Please ask for: Sian Eggington
Email: sian.eggington@terraquest.co.uk
Telephone: 0121 2341390
Our Ref: BR/116/20/HH
Your Ref:
Date: 29th May 2020

Application for Planning Permission for Works or Extension to a Dwelling

Development: Erection of single storey extension
Location: 3 Gordon Avenue West Bognor Regis PO22 9LQ

Proposed Site Plan

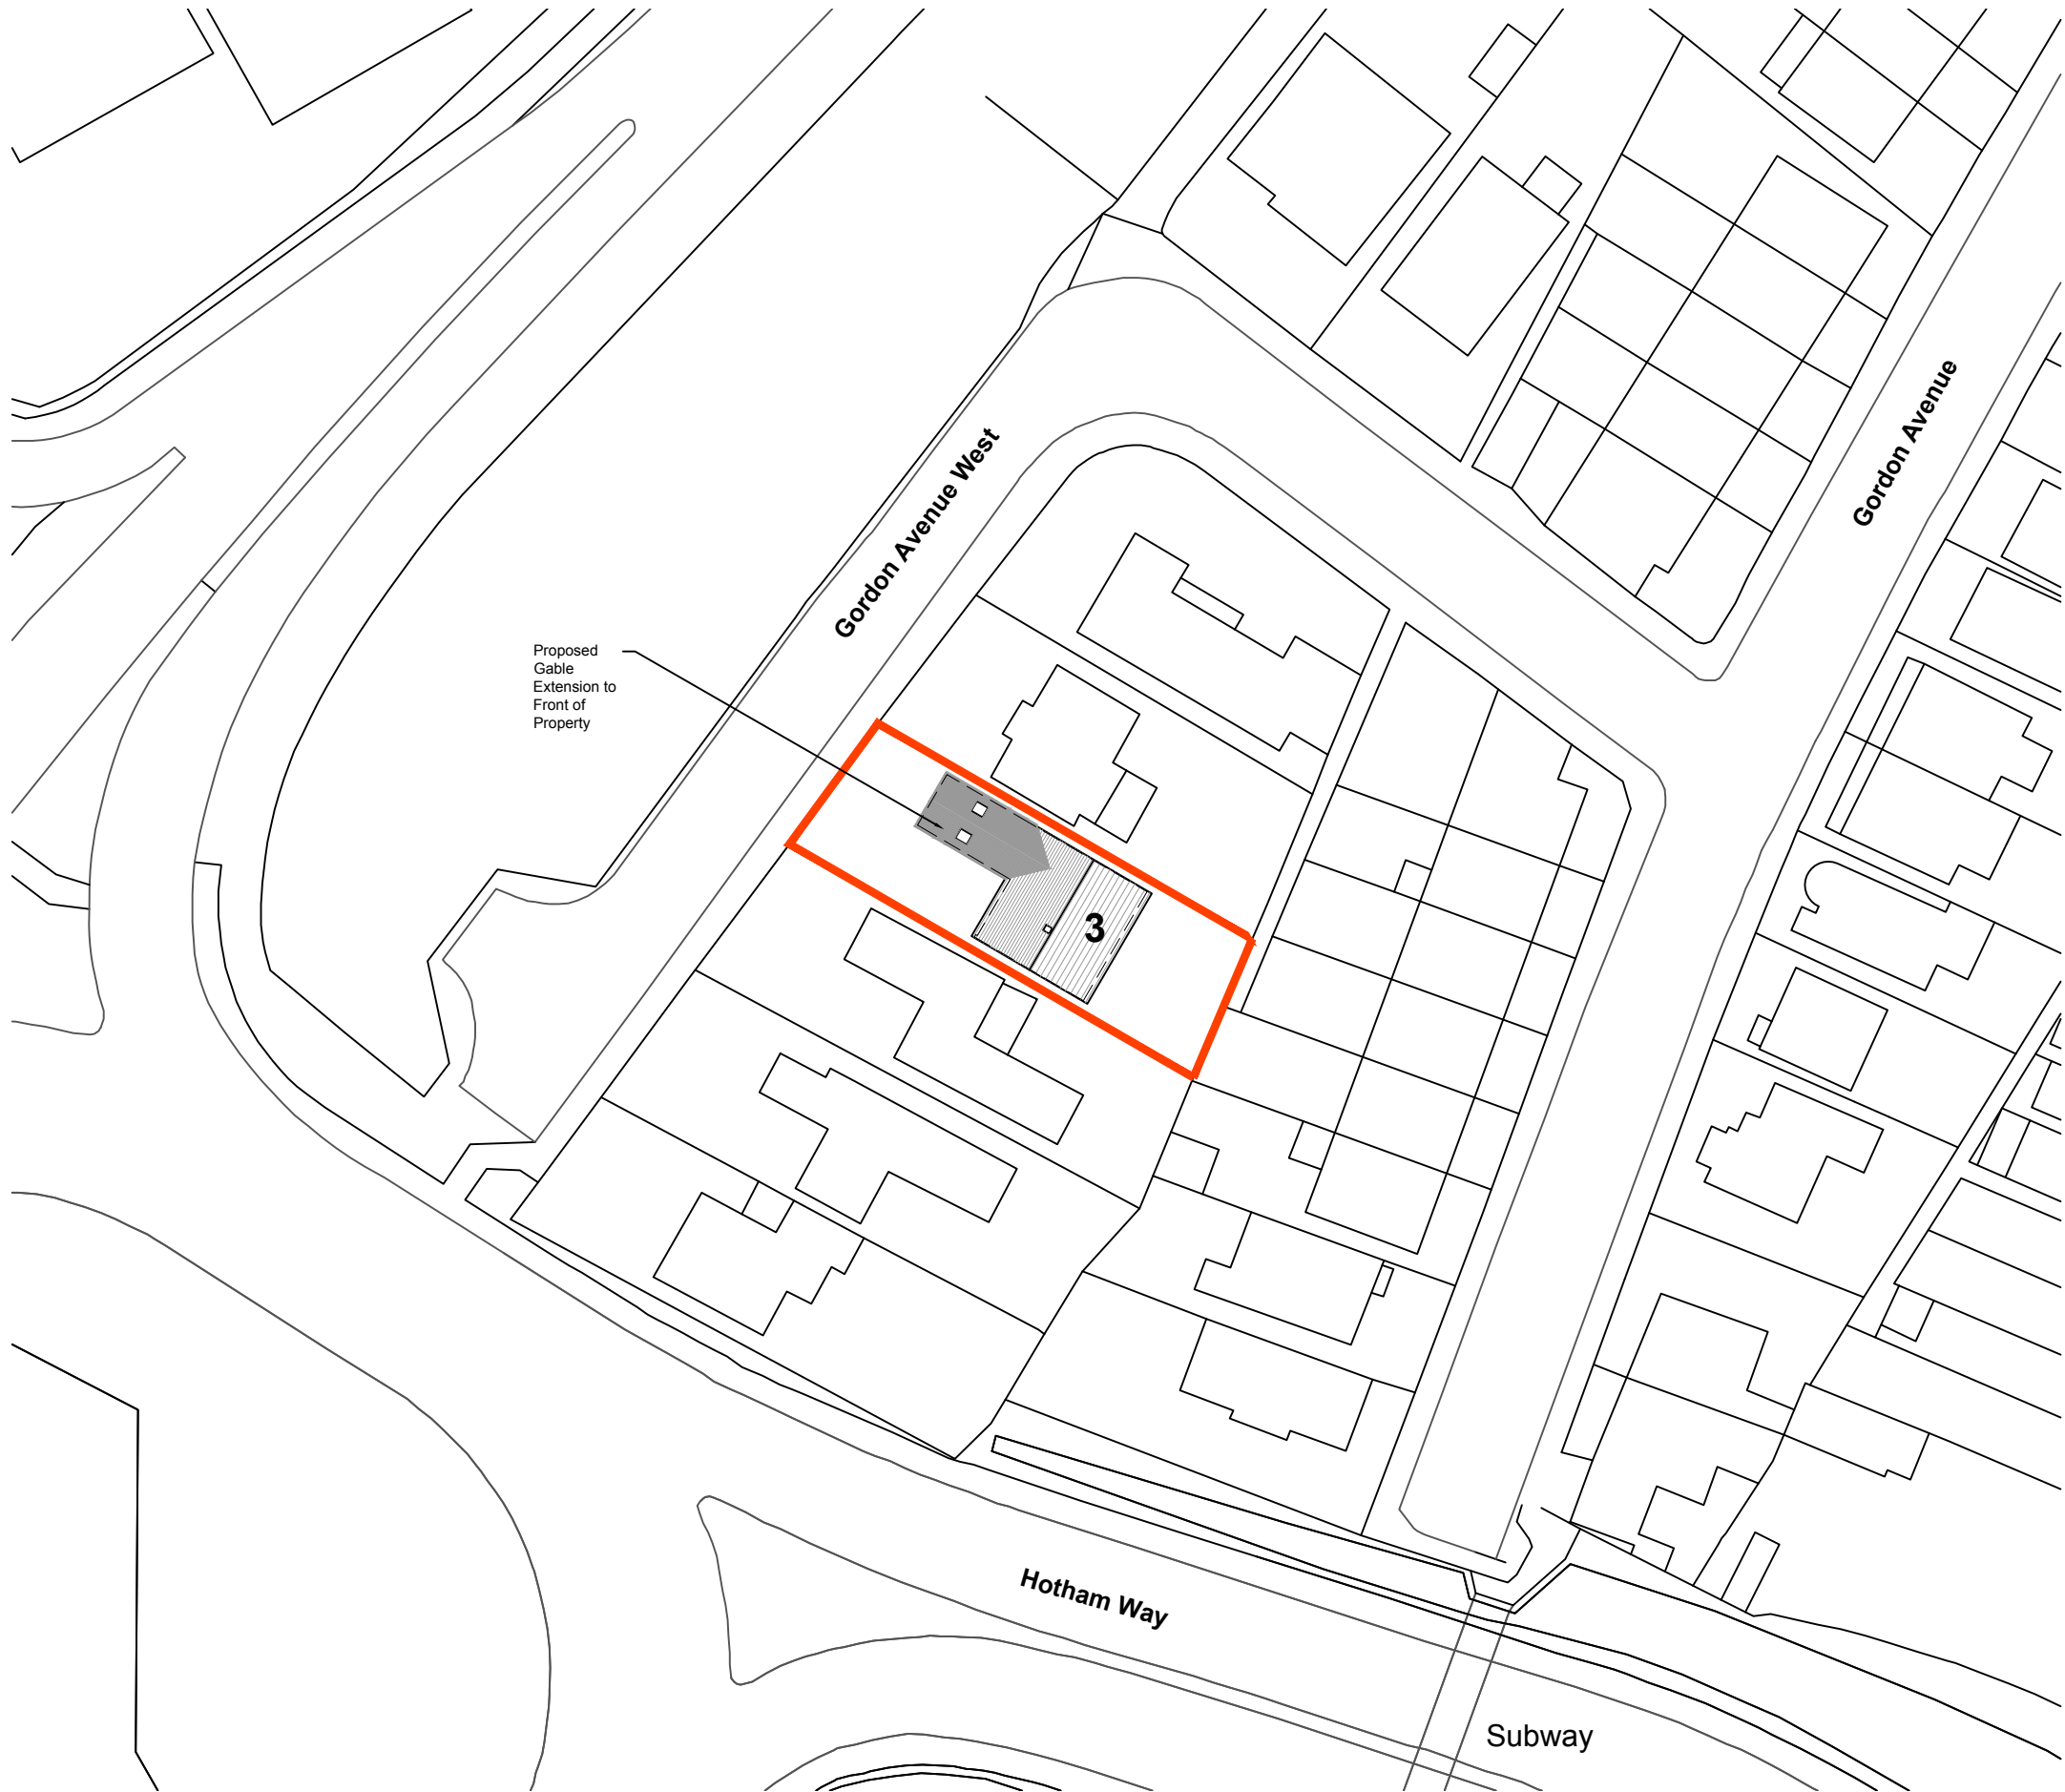
Block Plan: You are required to include dimensions from the proposed extension to all site boundaries. Please amend.
